Application No: 3/2021/0660 AND 3/2021/0661
Location: BOWLAND SECTION AND MARL HILL SECTION. WORKS AT VARIOUS LOCATIONS.
Proposal: PROPOSED WORKS FOR AND USE OF REPLACEMENT SECTION OF AQUEDUCT, INCLUDING EARTHWORKS AND ANCILLARY INFRASTRUCTURE INCLUDING: A NEW VALVE HOUSE BUILDING WITHIN FENCED COMPOUND WITH PERMANENT VEHICULAR ACCESS PROVISION. WITH THE INSTALLATION OF A TUNNEL PORTAL AND AN OPEN CUT CONNECTION AREA WITHIN A TEMPORARY CONSTRUCTION COMPOUND, TO INCLUDE SITE ACCESSES, STORAGE AREAS, PLANT AND MACHINERY, AND DRINAGE INFRASTRUCTURE AND A TEMPORARY HAUL ROUTE WITH BRIDGE OVER THE RIVER HODDER. IN ADDITION, A TEMPORARY HAUL ROUTE WITH BRIDGE OVER THE RIVER RIBBLE (AS ONE OF TWO OPTIONS FOR VEHICULAR ACCESS TO THE TEMPORARY CONSTRUCTION COMPOUND); A SERIES OF LOCAL HIGHWAY WORKS TOGETHER WITH A TEMPORARY SATELLITE PARK AND RIDE FACILITY AND A VEHICLE MARSHALLING AREA.

Summary

Director, Highways and Transport,
Lancashire County Council
Cuerden Mill • Cuerden Way • Bamber Bridge • Preston • PR5 6BS

SCALE N.T.S.	SHEET SIZE A3
DRAWING NUMBER RVBC-BO-APP-004-12_11	REVISION 0

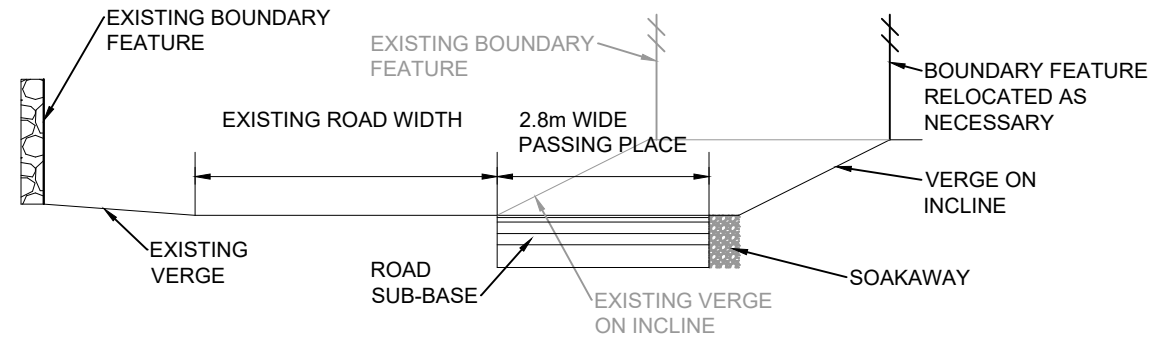
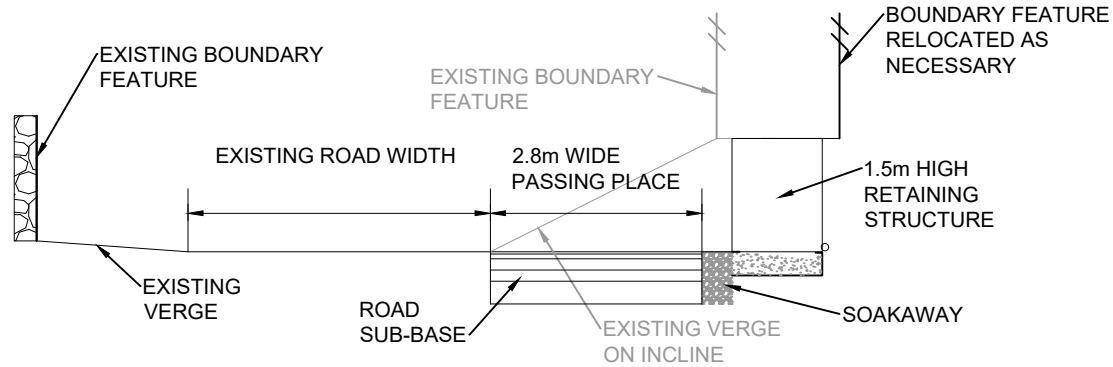
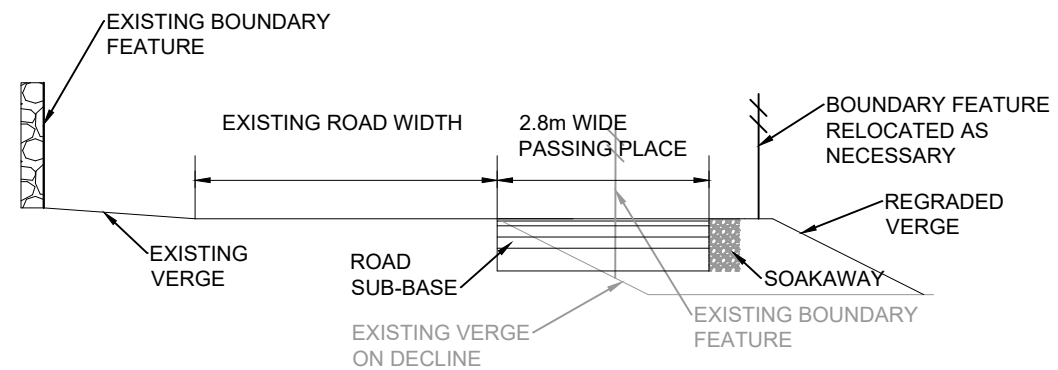
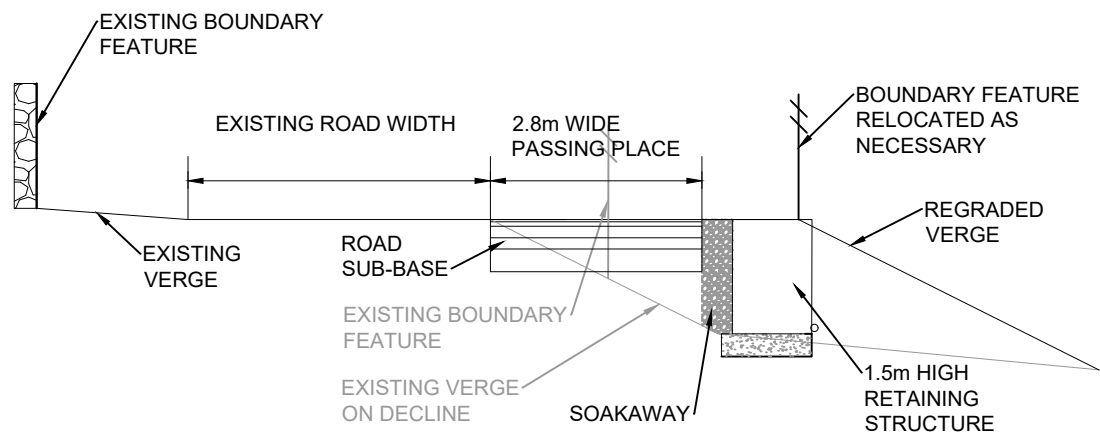
- With the formalisation of passing place PP01, and greater use of the passing place area, the area will require resurfacing. PP02 will require revising to ensure HGV can enter, wait and exit safely.

SCALE N.T.S.	SHEET SIZE A3
DRAWING NUMBER RVBC-BO-APP-004-12_12	REVISION 0

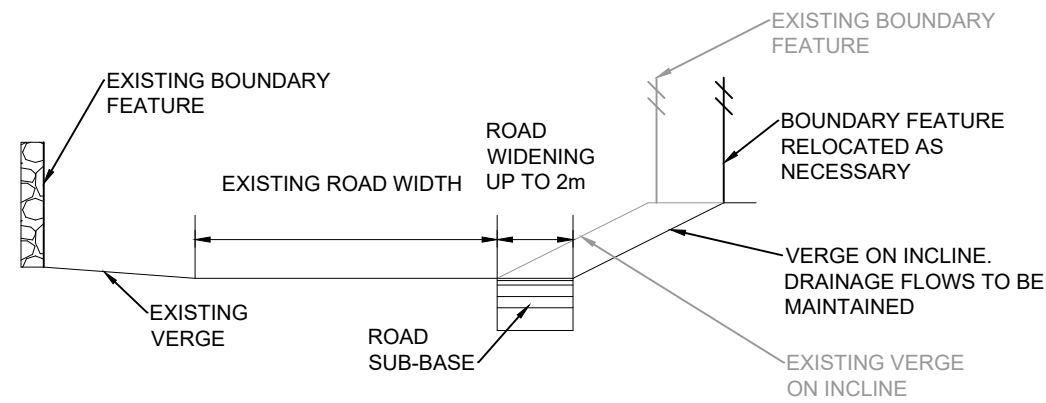
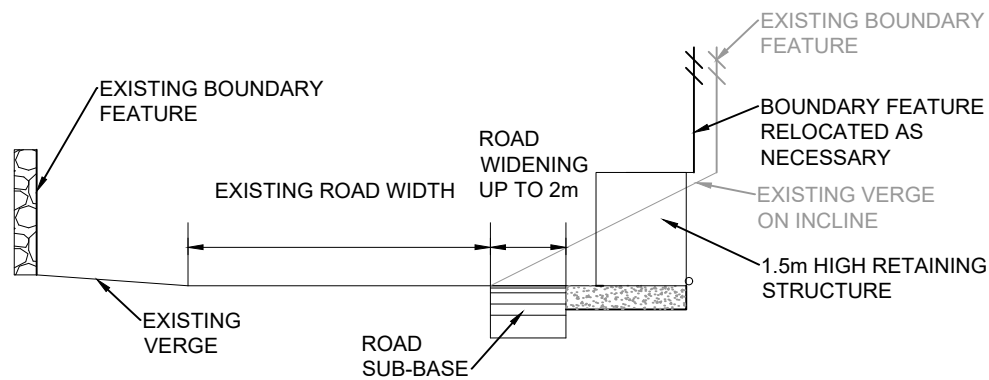
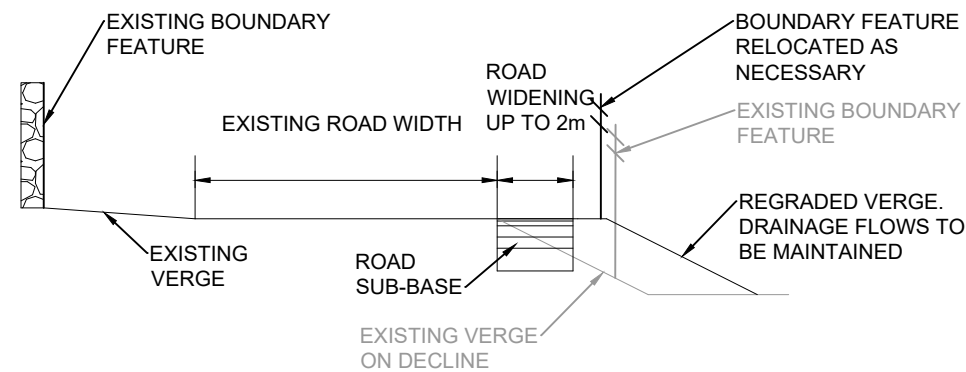
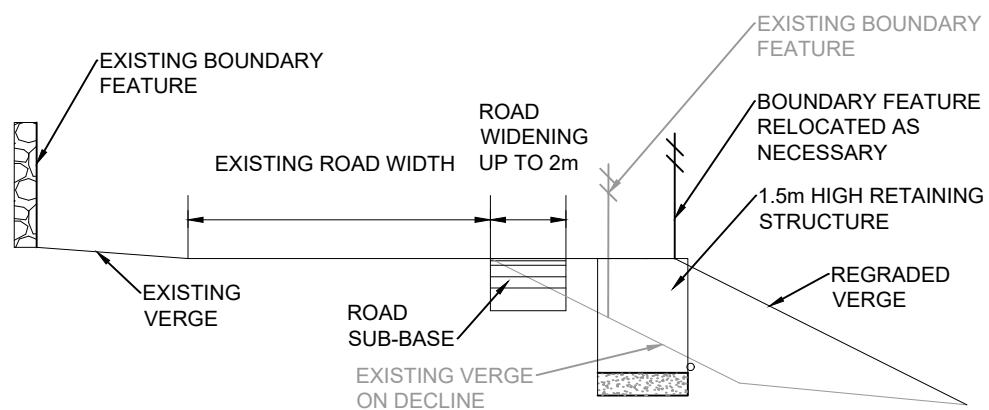
Along this section of route there are 22 road widenings proposed. After reviewing the location of the proposed widenings, a number of which are clearly required and others that appear to provide limited/no benefit.

- Those that should be constructed prior to the project are: RW12, RW15, RW16, RW23, RW24, RW26 and RW28. Once verge and foliage has been cut back, as suggested above, and the edge of the carriageway has been identified, some widenings as proposed may not be required, and others may be required (as a consequence of the SPA's background mapping being inaccurate).

- Proposed widenings, where possible, should not be on the same side as existing ditches, e.g., RW19 should be moved to the opposite side of the carriageway.
Note: to overcome safety issues, additional works will be required where widenings are proposed on the same side as ditches.

- All widenings are subject to detailed design having regard to infrastructure, carriageway alignment, topography, speeds and safety, e.g., RW28 may require lengthening and signage currently exists at RW26.
